## **WCC PAPER No. 2**

### **Winchester City Councils Comments on Ash Die Back Submission**

The ash Die back documents (Change Request No. 2) were submitted and published (16 December 2020) outside a normal “deadline” and consequently have been placed in the Examination library under additional submissions AS-052- AS-053 & AS-054. The Council did make some initial comments on this proposal at Deadline 3, which is recorded as REP6-088. A combination of more time to review the submission documents together with a meeting with the applicant has allayed the concerns of the Council regarding the extent of the ash dieback assessment.

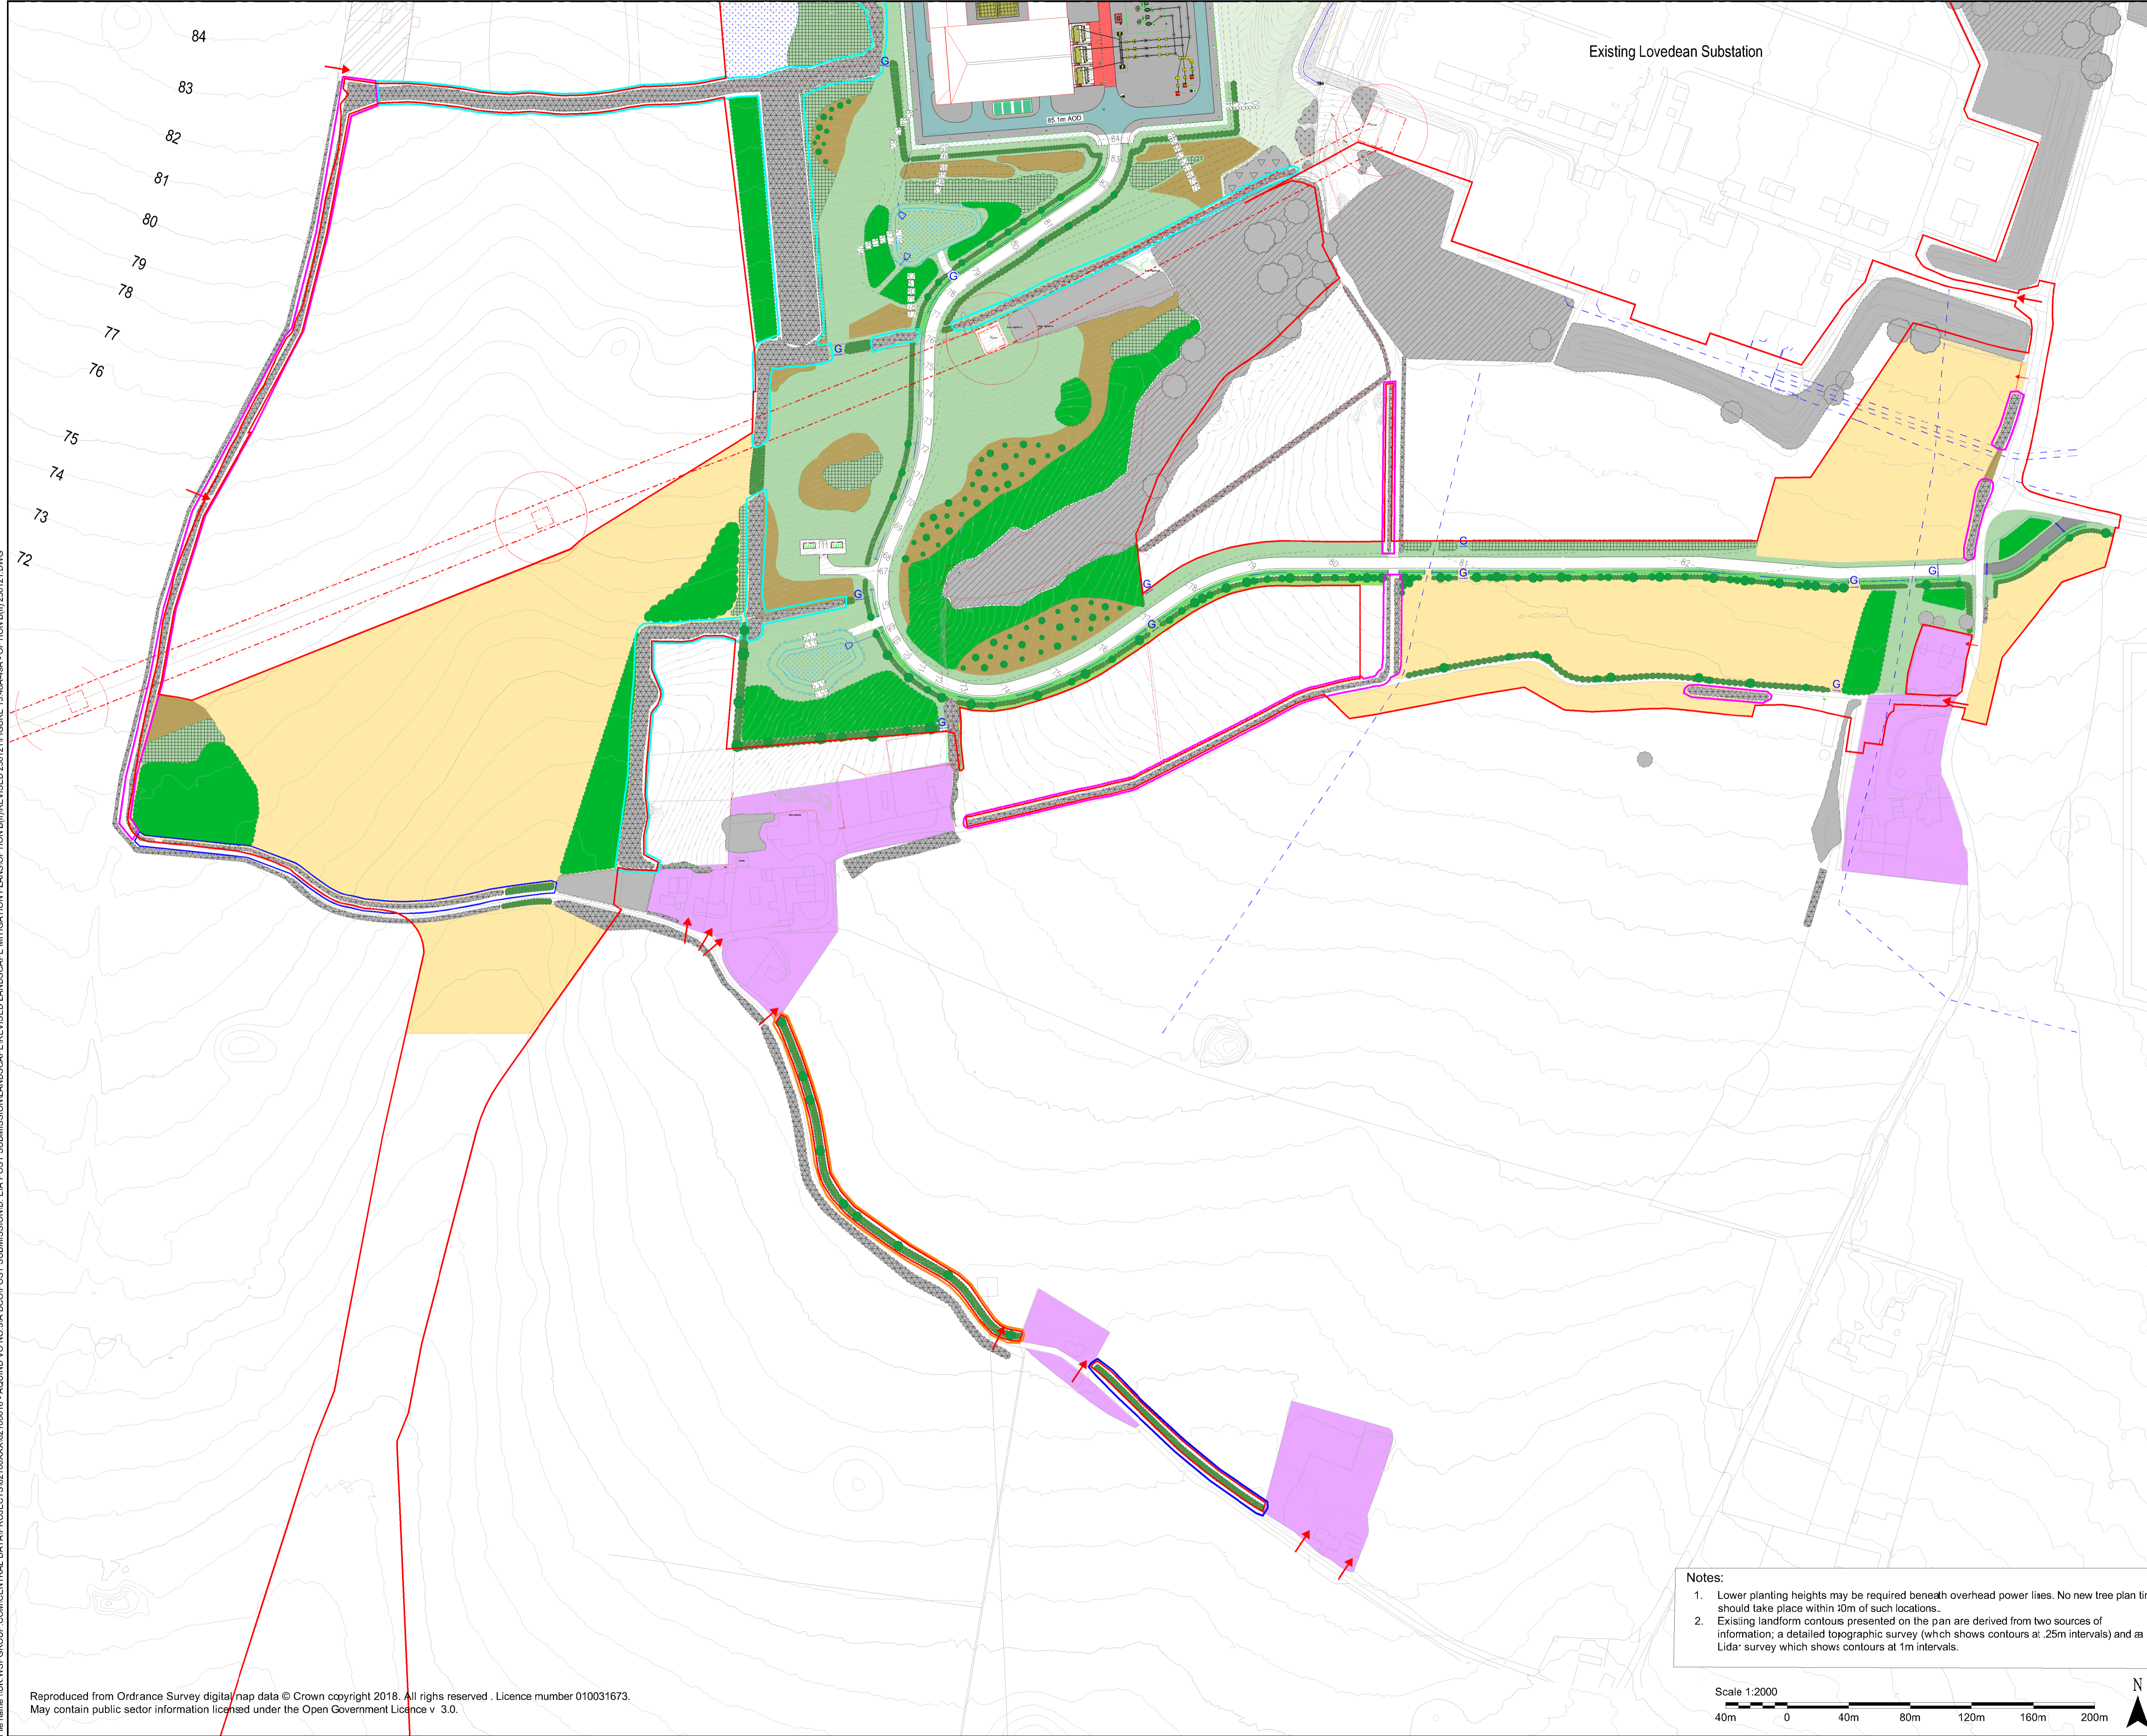
The new planting belt is referred to at section 3.1.1.2 in the document Request for Change to the Order Limits (AS-054). This new belt is annotated as PW27 on the plan attached as appendix 2 to the OLBS Rev 003 (REP-038). However, this land is not shown within the changed Order Limits as shown on sheet 1 of the Land Plans Rev04 (REP6-004). In appendix 2 of the Request for Changes to the Order document reference is made to an “option for easement” with Winchester College to secure the planting and New Landscape Rights.

If this land is not within the Order Limits, it is under clear exactly how the planting, maintenance and long term management can be secured with a link back to the DCO requirements.

A second question is whether the requirements need some explicit reference to the proposed actions and specifically those which will apply to Stoneacre Copse, where the necessity to balance the maintenance of the habitat with the maintenance of the landscape screen needs to be considered. There are a number of publications that offer good practice on management such as:
